TECHNICAL NOTE				VELOCITY	
Client	The Kingsborough Centre			Page No.	1 of 17
Project	Technology House			Project No.	25/072
Subject	Transport Statement Addendum			Document No	TN002
Prepared By	JEH	Checked and Authorised By	JH	Date	MAY 2026

1.1.1 This Transport Statement Addendum has been prepared by Velocity Transport Planning in response to highway concerns raised by the London Borough of Hillingdon (LBH) in relation to the planning application for Technology House:

“Change of Use from mixed Class B8 and Class E to mixed Class B8, Class E and Class F1 (community and learning use)”.

Figure 4-1 Proposed Parking and Access Approach

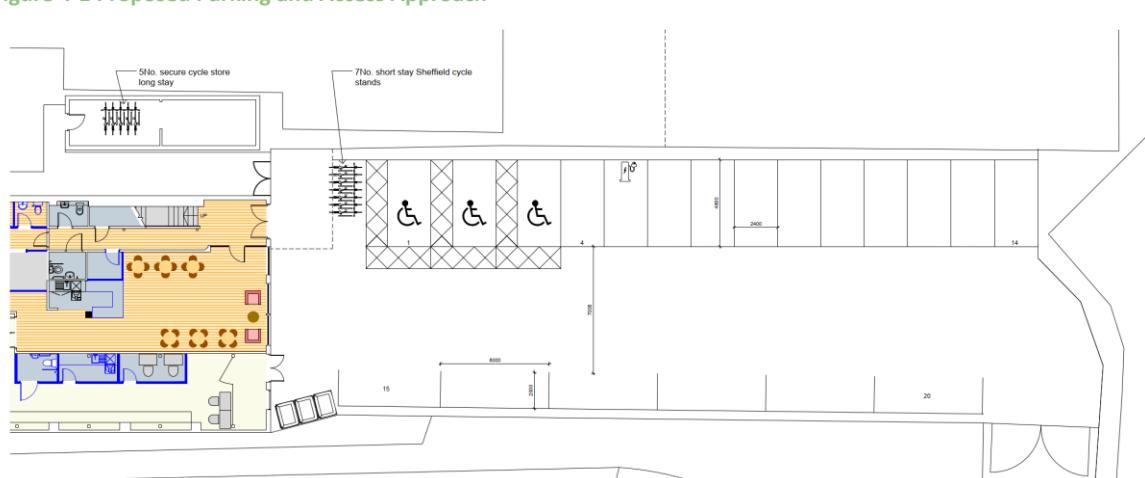
- 7.1.1 LBH raise concerns regarding the reliance on the Tesco car park to accommodate additional parking demand associated with the development. It is noted that the Applicant has proposed to secure the use of up to 50 spaces within the Tesco Superstore car park; however, the submission does not include sufficient evidence to demonstrate that this arrangement is deliverable or acceptable in practice.

- 7.1.2 In particular, the Authority highlights that *“there is no evidence submitted to substantiate this agreement nor is there any evidence that there is capacity within the Tesco car park to withstand the loss of parking during peak times.”*

- 7.2.1 LBH’s concerns regarding the use of the Tesco car park are noted, particularly in relation to the absence of evidence demonstrating that the arrangement is secured and that sufficient capacity exists. In response, the Applicant confirms that a formal agreement with Tesco has been reached, and this is now provided in **APPENDIX D** addressing the previous uncertainty regarding deliverability and legality. This agreement allows the proposed development to utilise up to 30 spaces of the Tesco car park for Sunday morning worship sessions. The parking survey evidence below shows that there is spare capacity in the Tesco car park during this period.

Figure 4-3 Proposed Access Strategy Plan View

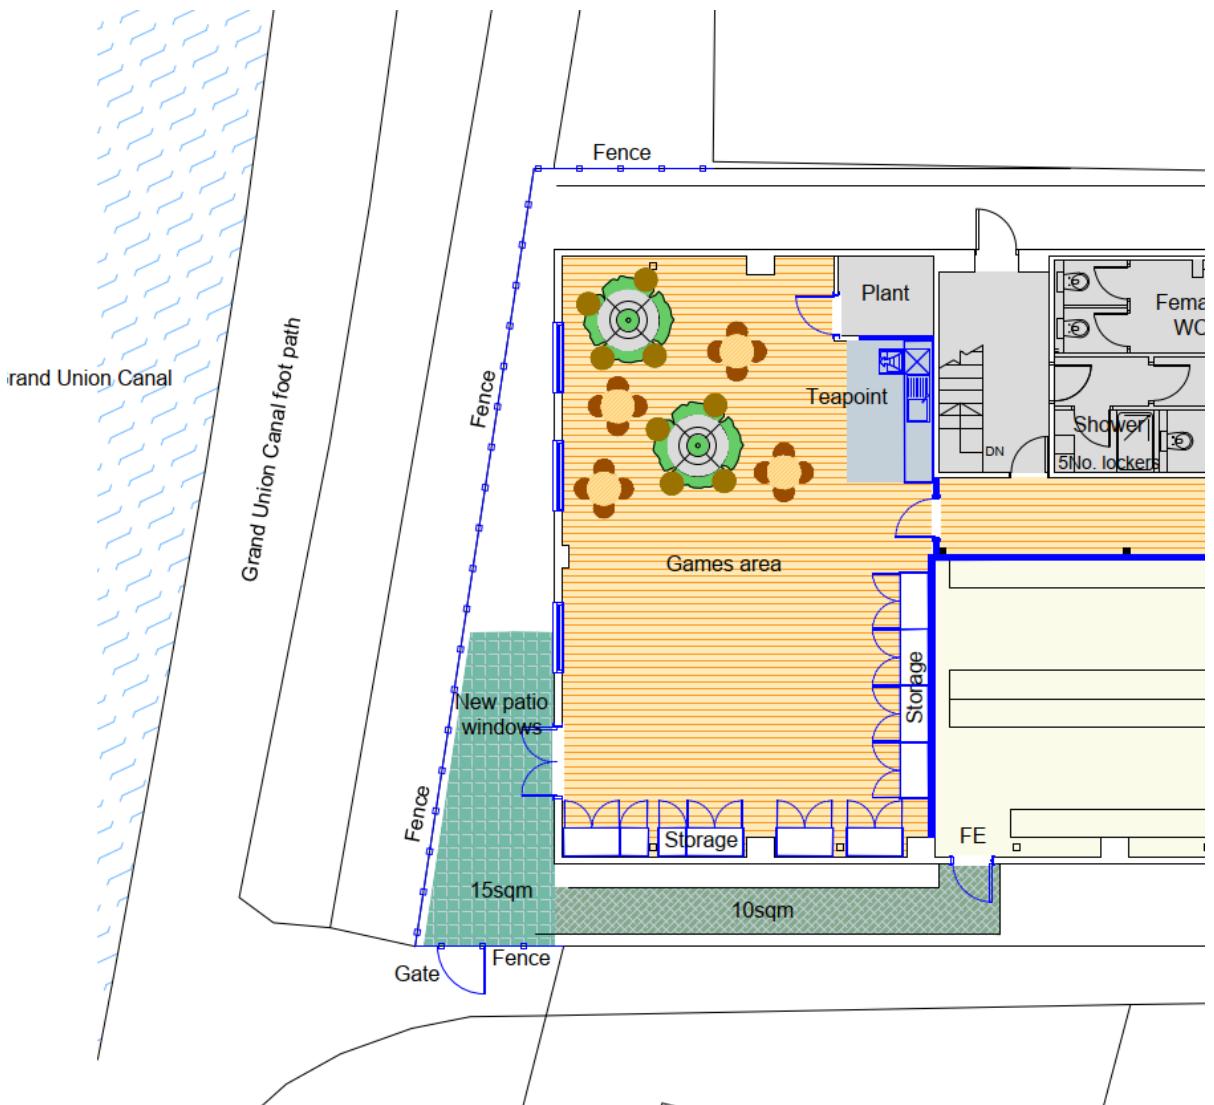
2.1.1 One of LBH's primary concerns relates to the assumption that pedestrians and cyclists would be required to move through the operational centre of the Shell forecourt between the fuel pumps and the car wash. The comment is as follows:

"The proposal would require the service users and to cross the petrol garage forecourt between the petrol pumps and car wash, which is a busy environment with a number of conflicting vehicle movements. While the proposal states that the owner of the application site has right of access over the petrol forecourt to gain access to the building, given the significant increase in movements (pedestrian, vehicle and cyclist) and the lack of segregated spaces for safe access for those who walk or cycle to the location a highway objection has been raised. There may well be access rights over the land, but these would not provide the Applicant with the authority to install furniture or a boundary treatment to protect pedestrians and cyclists from the conflicting vehicle movements within this area."

"The pedestrian and cyclist access would cross in front of the car wash within the yellow square and behind the petrol pumps located underneath the canopy labelled shell forecourt. The petrol garage has a 1-way system for access and egress, the access is to the south of the forecourt canopy, and the egress is to the north of it. There is a real concern that pedestrians and cyclists will ignore this (even with appropriate signage which cannot be installed without third party consent) and exit onto the main highway through the entrance into oncoming vehicles. In some cases you can reasonably expect those who interact with an application site to adhere to signage etc in order to prevent obstruction or collision, in this instance the Applicant has no authority or ownership to install signage on third party land, there is a significant increase in individuals accessing the site and no realistic improvements or controls for accessing the have come forward."

2.2.1 It is important to clarify that the development does not require pedestrian movement through the central operational areas of the forecourt (between the pumps and car wash).

2.2.2 Instead, a revised pedestrian access route has been agreed with Shell which utilises the existing pedestrian footway running along the frontage of the Shell retail building. This route provides access from the A408 footway network directly to the application site via a new pedestrian gate between the Shell forecourt and the site boundary. The route features:

- ⦿ A defined pedestrian route across the front of the Shell forecourt building, accessed via a pedestrian only footpath at the north of the Shell garage from the footway of the A408.
- ⦿ This route is located away from the fuel pump islands and car wash circulation area, and as such is away from vehicle movement.
- ⦿ It represents a route around the perimeter of the Shell Garage avoiding key conflict areas.
- ⦿ The route utilises a footway by the Shell shop building.

Figure 7-3 Proposed Rear Access

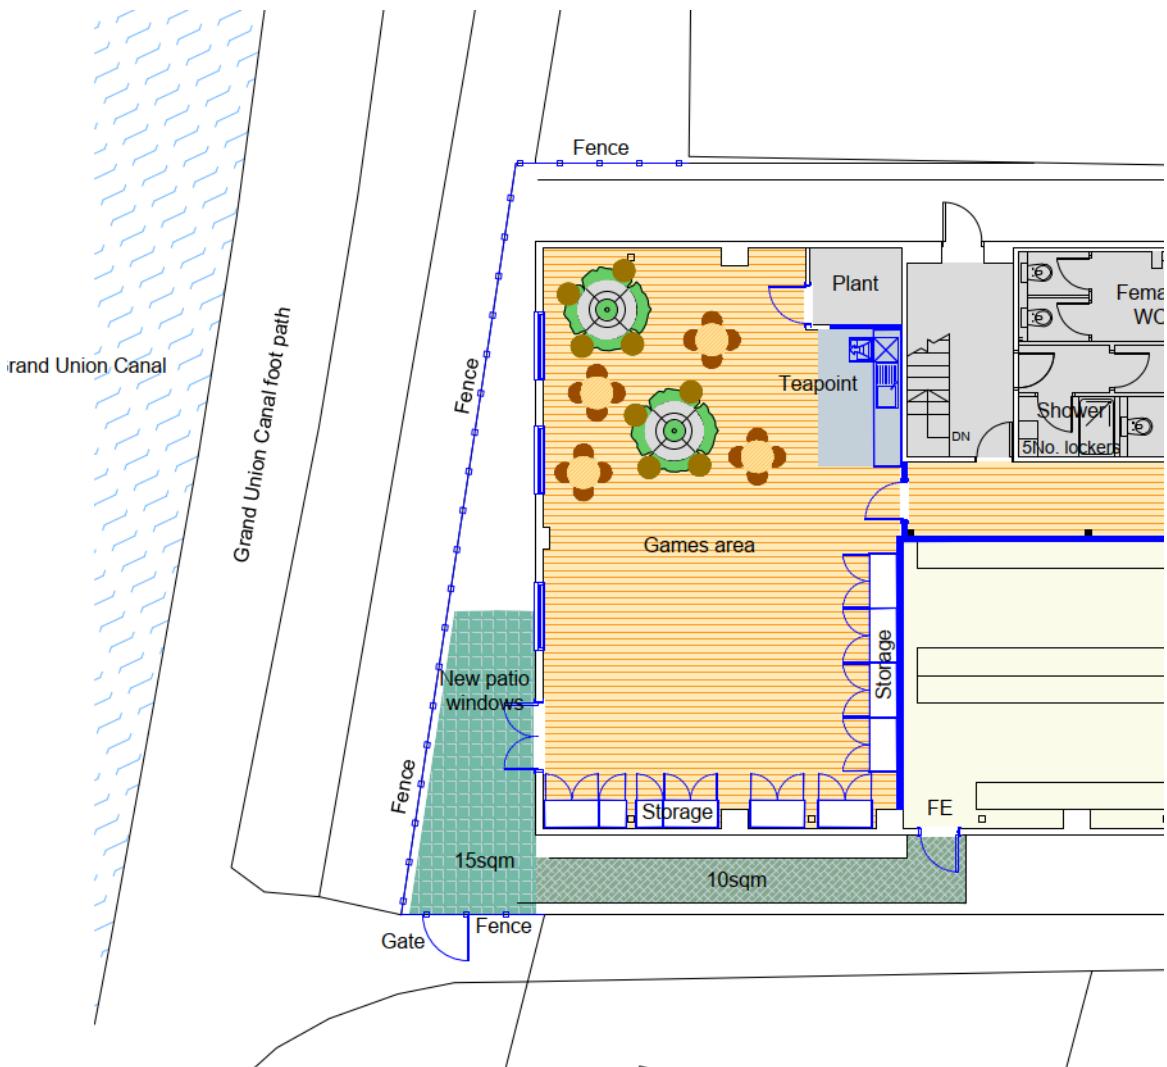
- 5.1.1 As outlined in the submitted TS the Applicant has proposed to open up the rear of the site, with a pedestrian access to the Grand Union Canal Towpath.
- 5.1.2 LBH acknowledged that the rear access via the Grand Union Canal towpath is a potential mitigation measure, and that it could provide a safer, traffic-free alternative for pedestrians and cyclists access the Site. However, the LBH feedback raised the concern that it is likely to be less attractive as a route in autumn and winter. It is assumed that this feedback is referring to lighting conditions and perceived safety.
- 5.1.3 Whilst the feedback is acknowledged, further consideration should be given to the route as a means of access.

- 5.3.1 The towpath is specifically proposed as the primary pedestrian route for Sunday morning services only, which represent the peak period of attendance. This is a critical distinction. Sunday morning arrivals are characterised by daylight conditions, short and concentrated arrival windows, and a higher proportion of users travelling on foot. In this context, the towpath provides a direct, traffic-free and attractive route, particularly for those approaching from the south, including West Drayton Station. As such, it is well suited to accommodate a significant proportion of pedestrian movements during this peak period.

- 5.3.2 In contrast, the towpath will not be relied upon for Wednesday evening use, when conditions may be less favourable (during darker hours). This reflects the different travel characteristics of that period, where attendance is lower and the majority of users are expected to arrive by car sharing and minibus. As a result, pedestrian demand is inherently limited on Wednesdays, and there is no dependence on the towpath during times when its attractiveness may be reduced.
